MONUMENT RIDGE EAST – FDR COMMENT RESPONSES

June 24, 2026

FOREBAY "4-B" TEMP. NOTCH PLATES
SCALE: N.T.S.

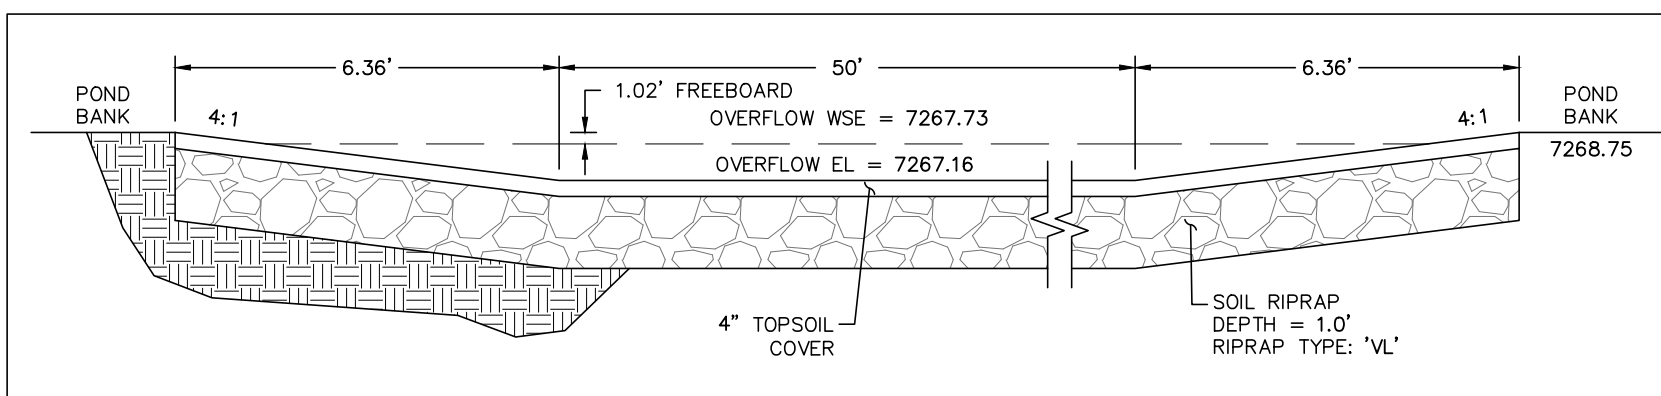
18. The CD's now reflect the metal notch design you have requested.
